**ANNE B. PRINGLE**

January 23, 2018

Planning Board  
City of Portland  
389 Congress Street  
Portland, ME 04101

Re: Maine Medical Center

Ambulance Routes

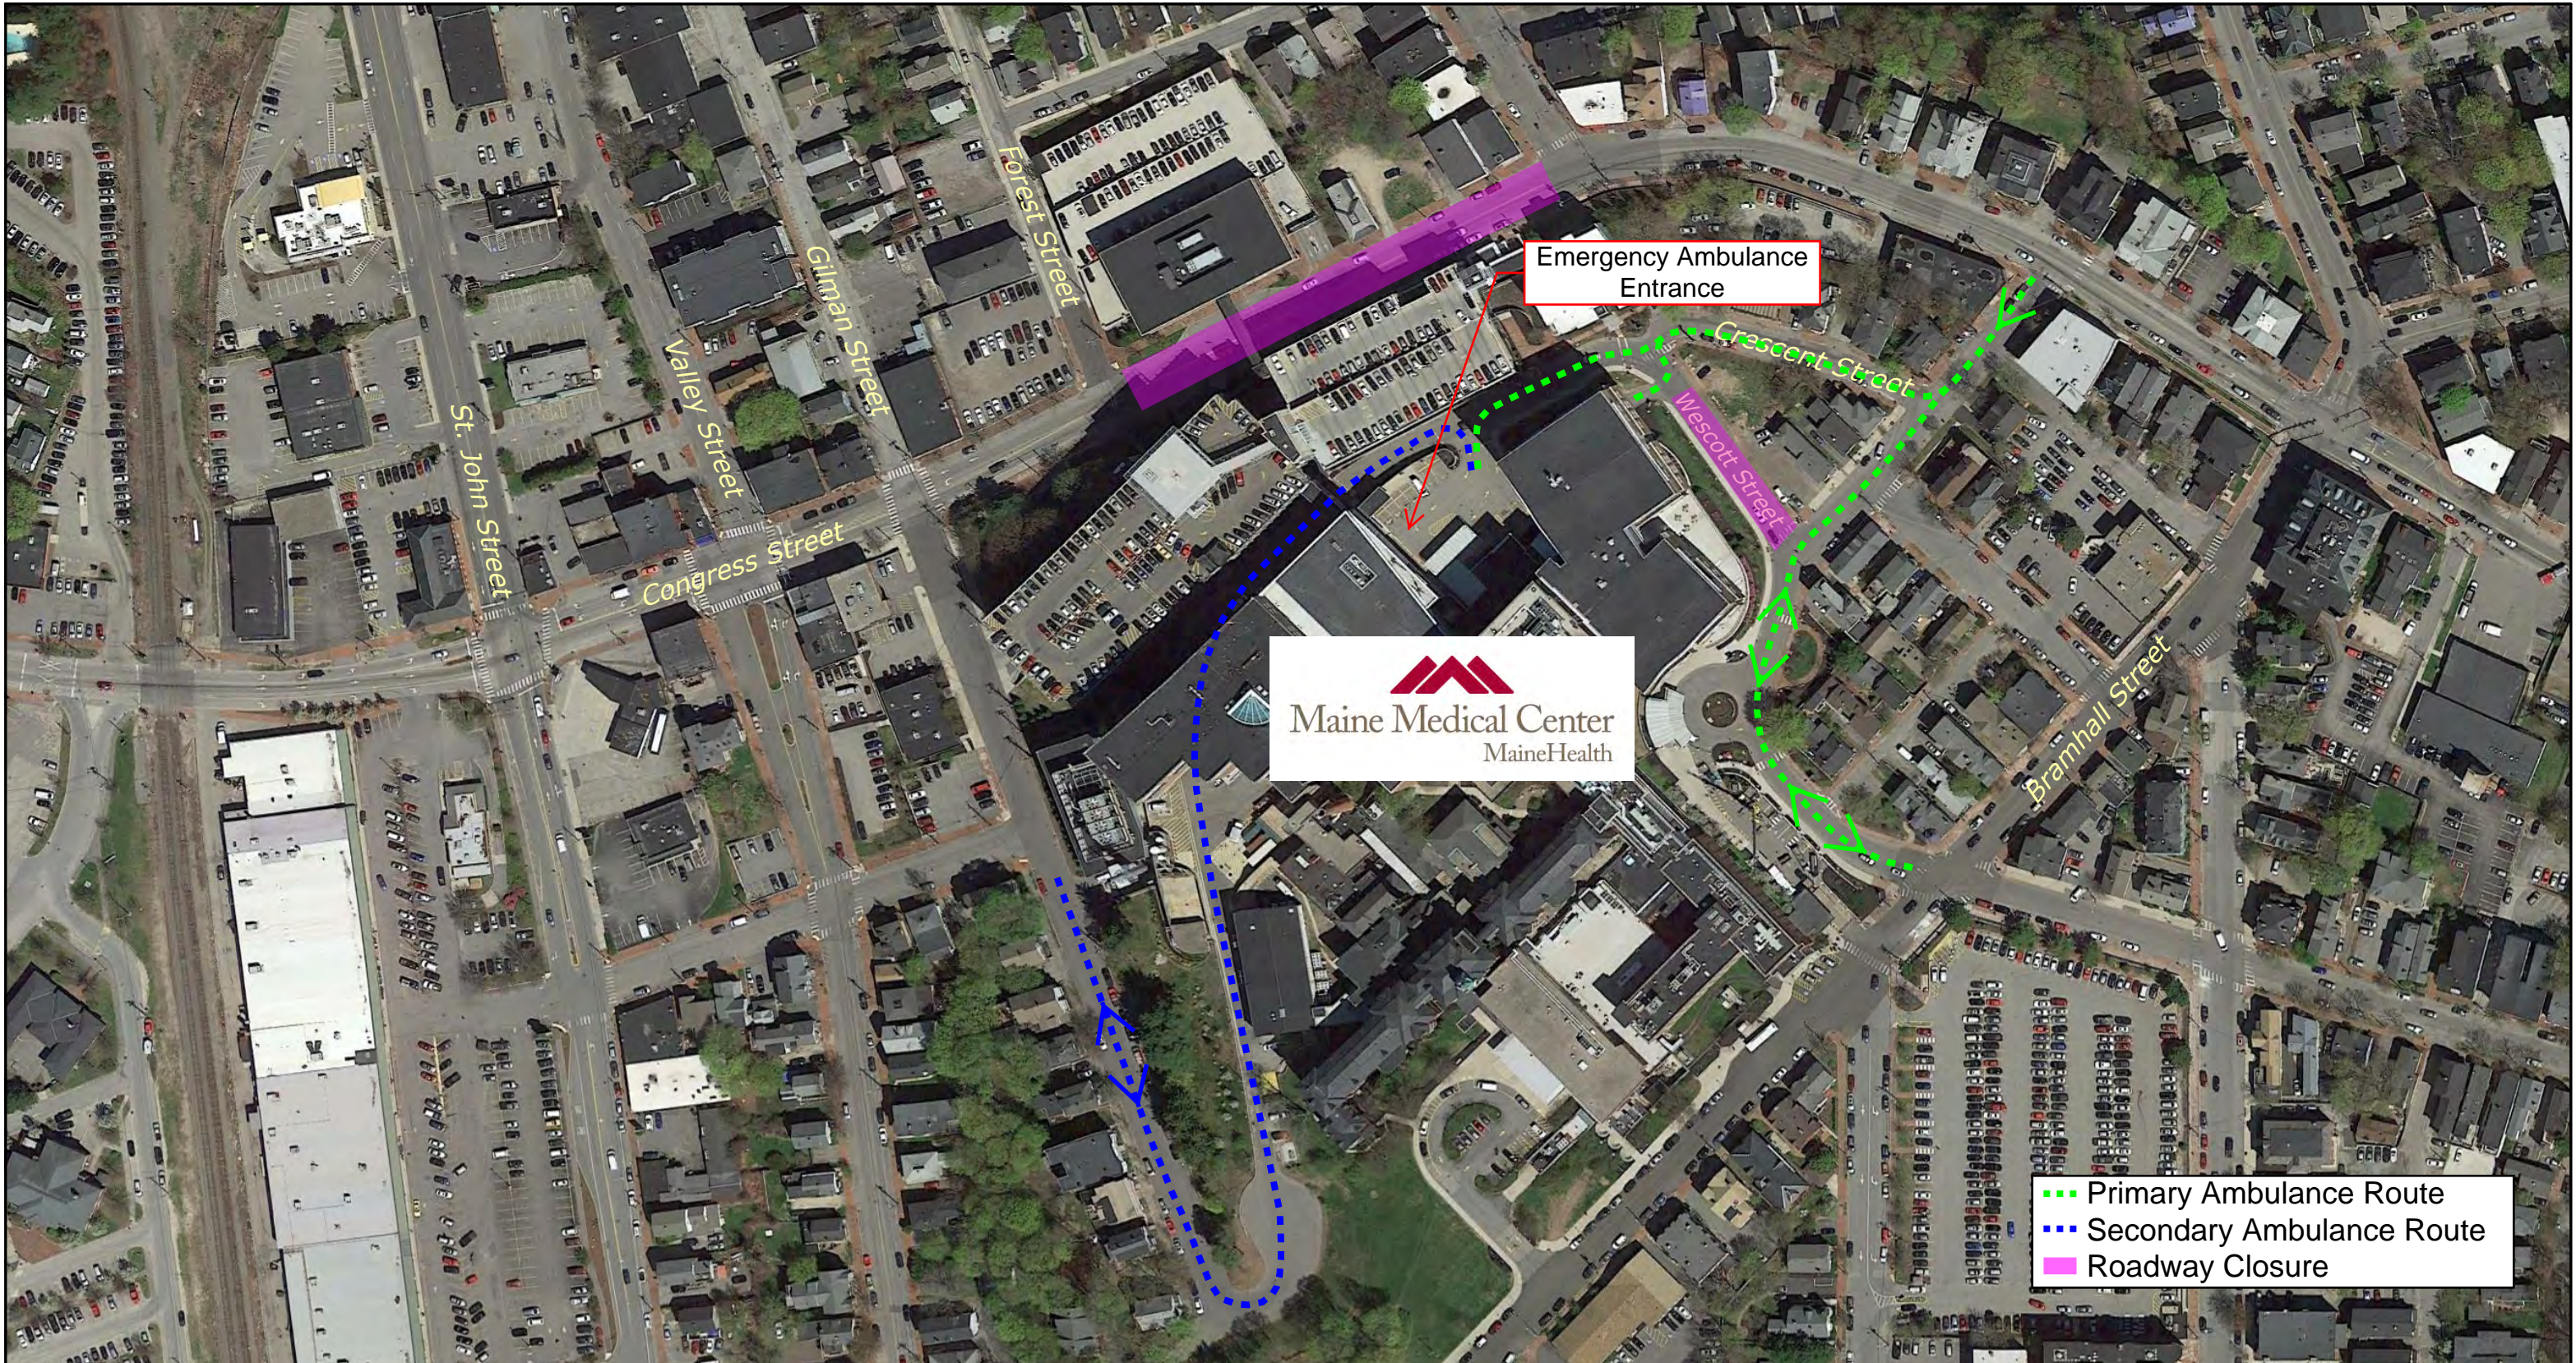
3) I think it is very important to develop a realistic detour plan for Congress Street during the time it is closed during construction. The initial detour plan to divert traffic within the neighborhood does not make any sense, in my view. Unlike the debacle on State Street during the recent closure, the City should affirmatively direct traffic to a well-developed detour route, not just leave the heavy volume of traffic that uses Congress Street to find its own way...

Visitor Garage Expansion

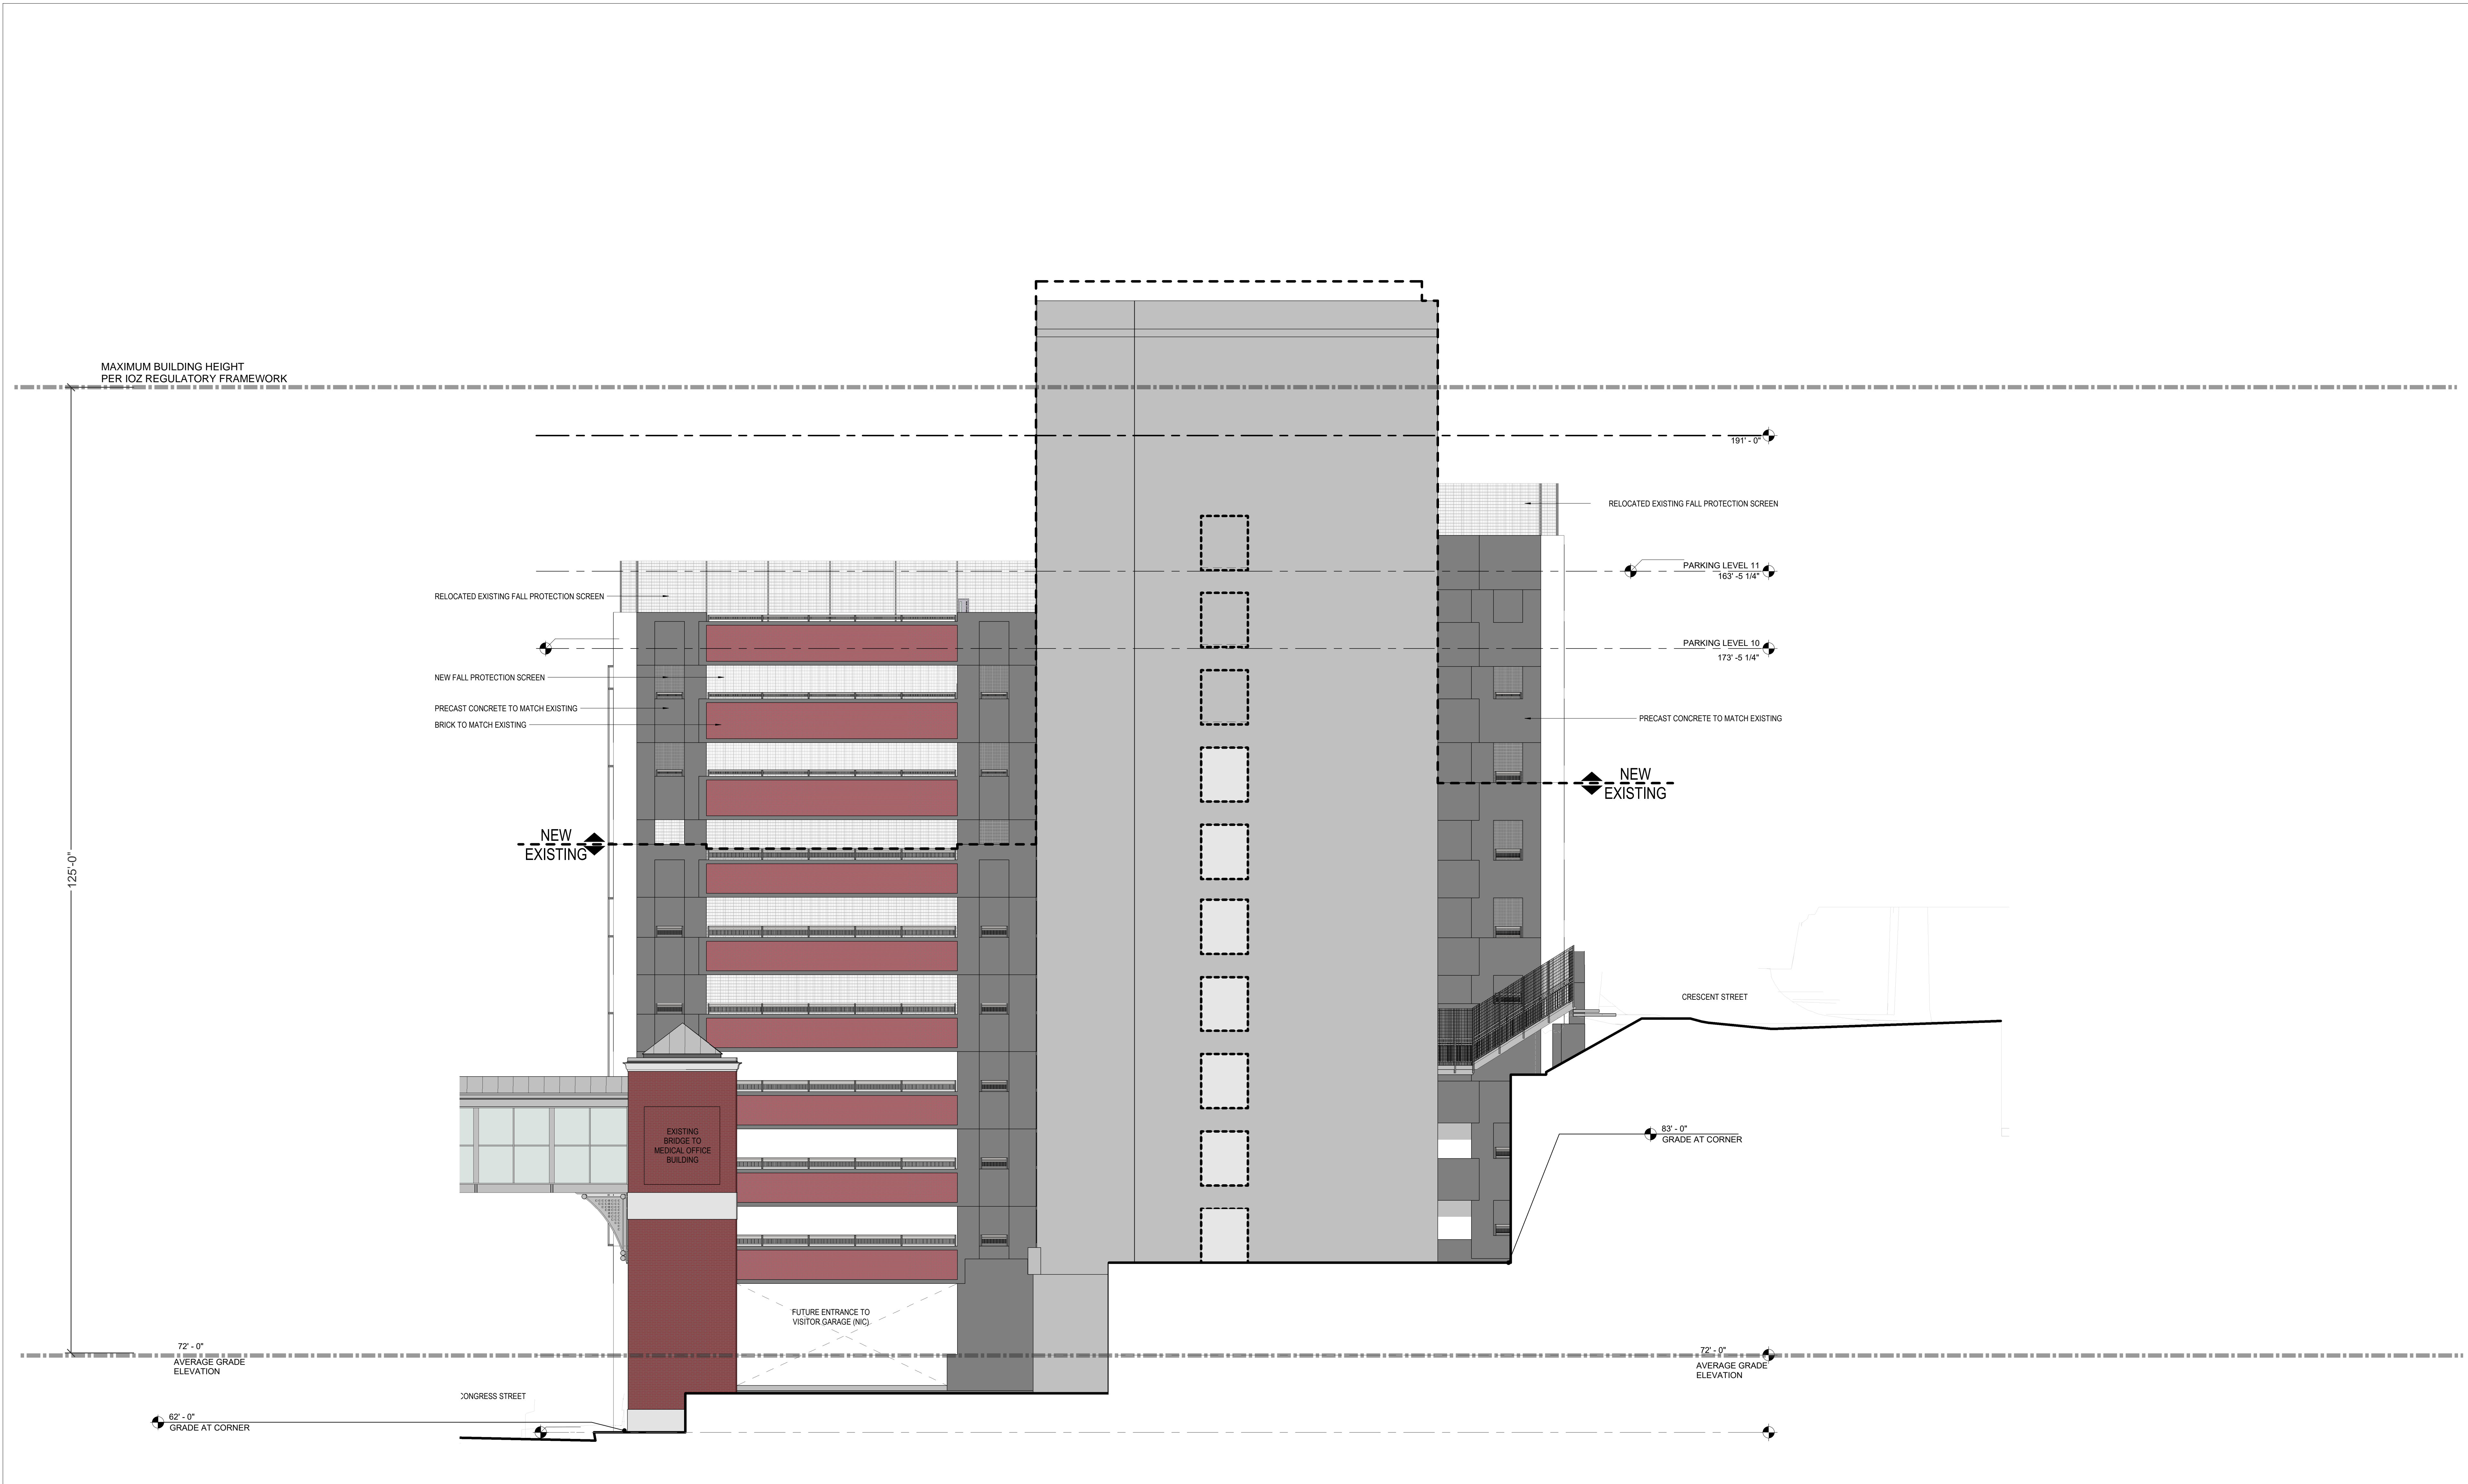
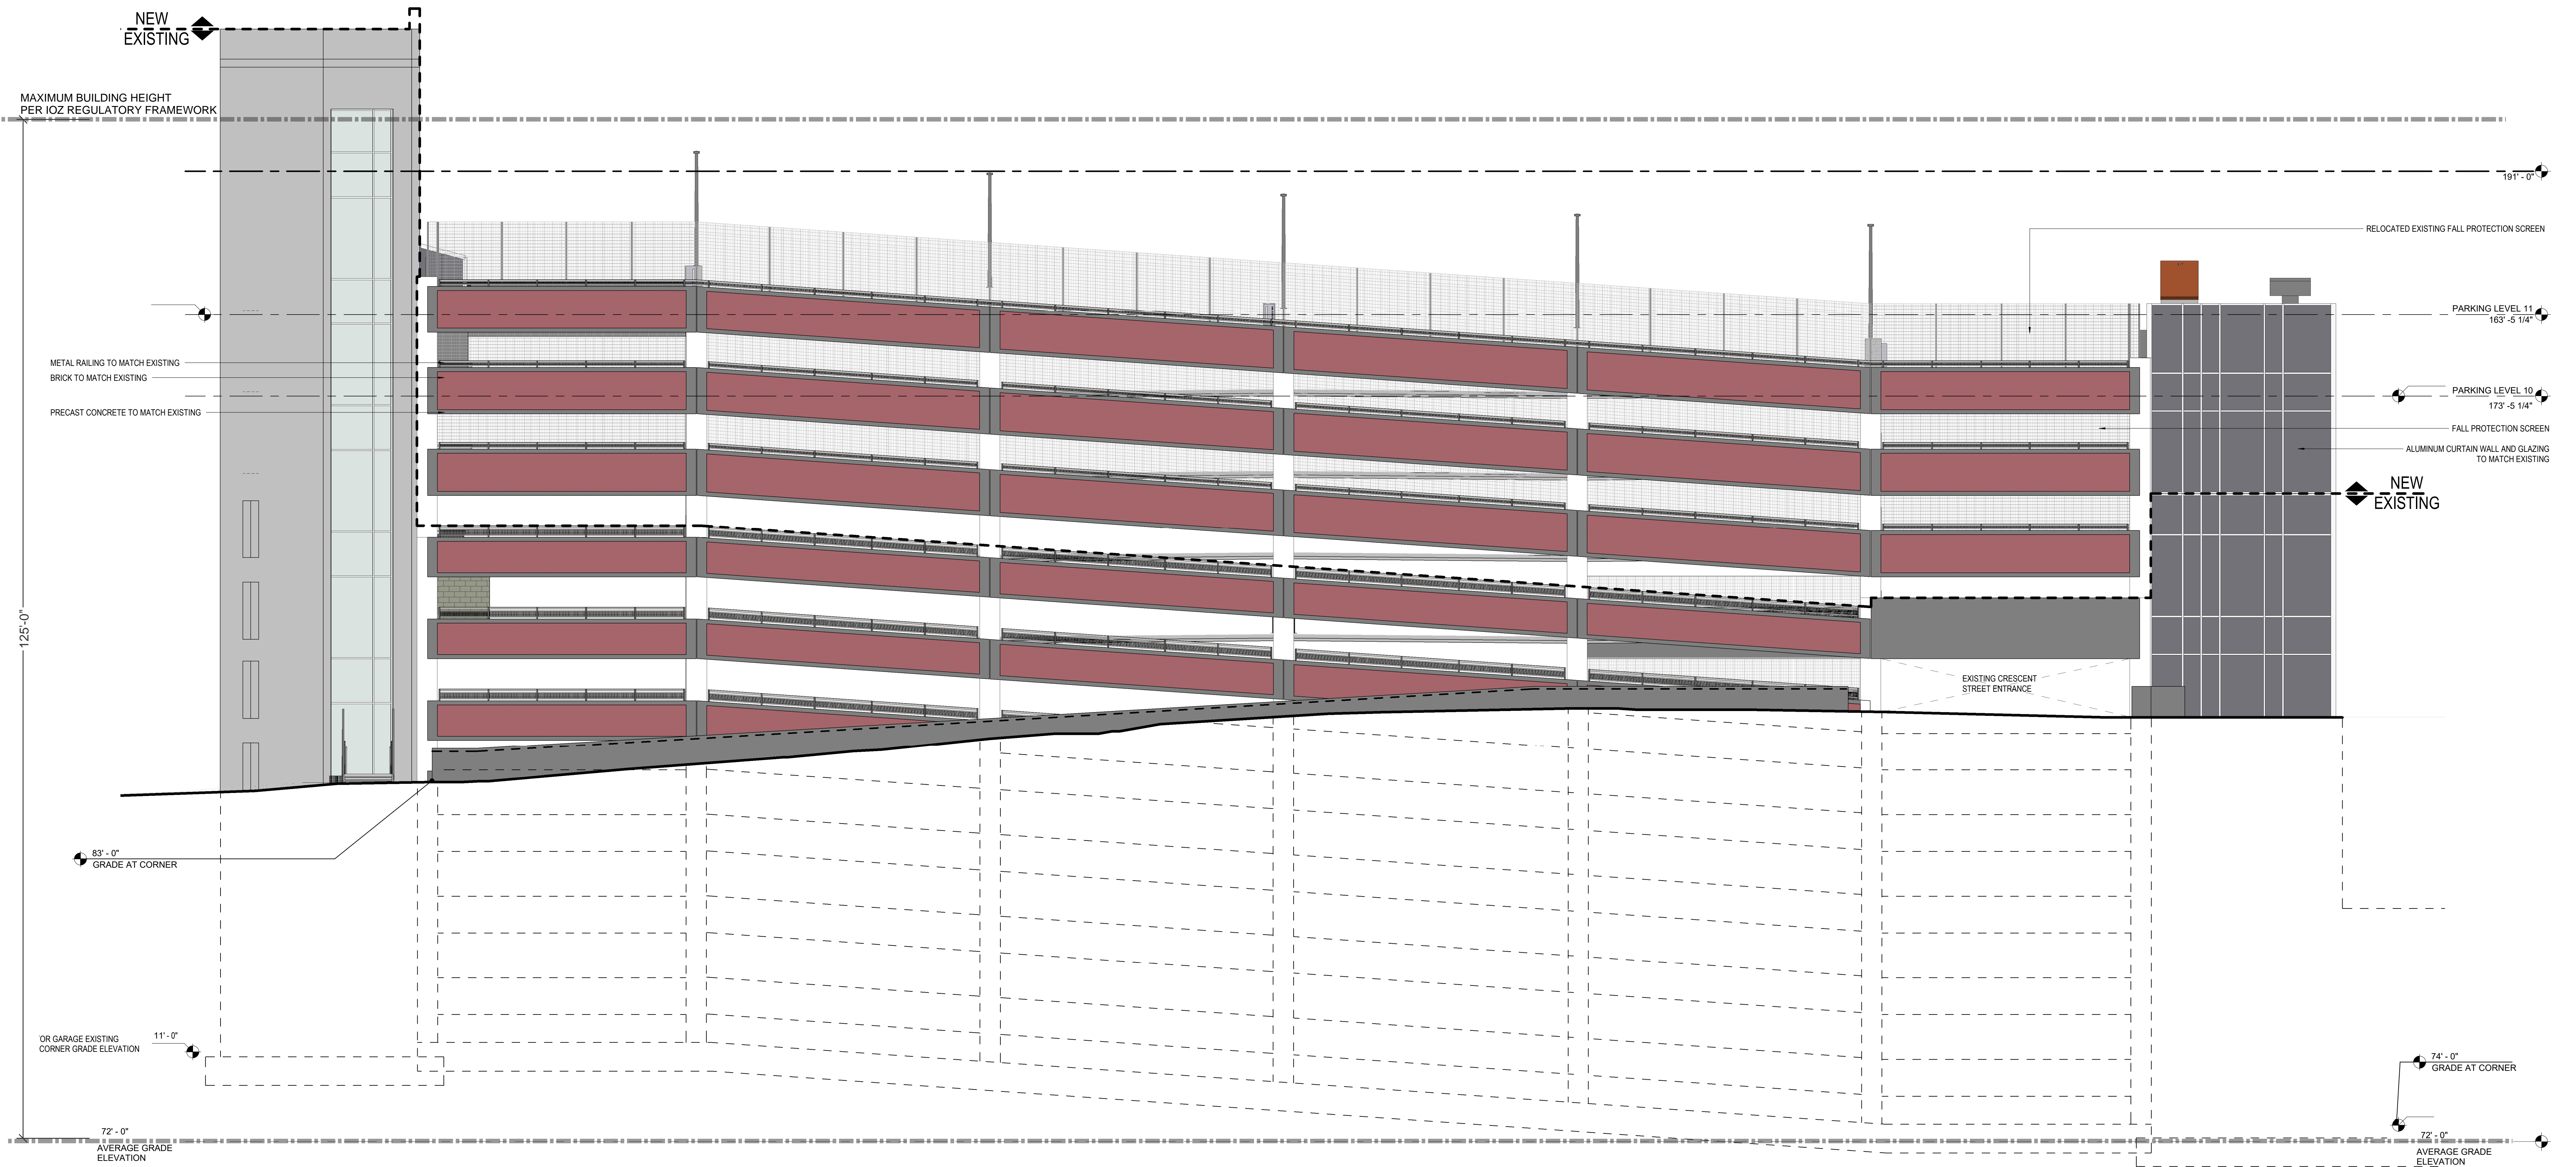
2) Almost everyone acknowledges that it has been a disappointment that the Congress Street retail space has been vacant since it was partially finished many years ago. I understand that the space will be used for construction purposes. But I think it is essential to establish a requirement that a use be in place in that space within so many months after the project completed or a penalty of some sort will be assessed. While not an ideal space, especially in its unfinished condition, there must be some viable use for that space that will enliven the street, as required in the IDP!
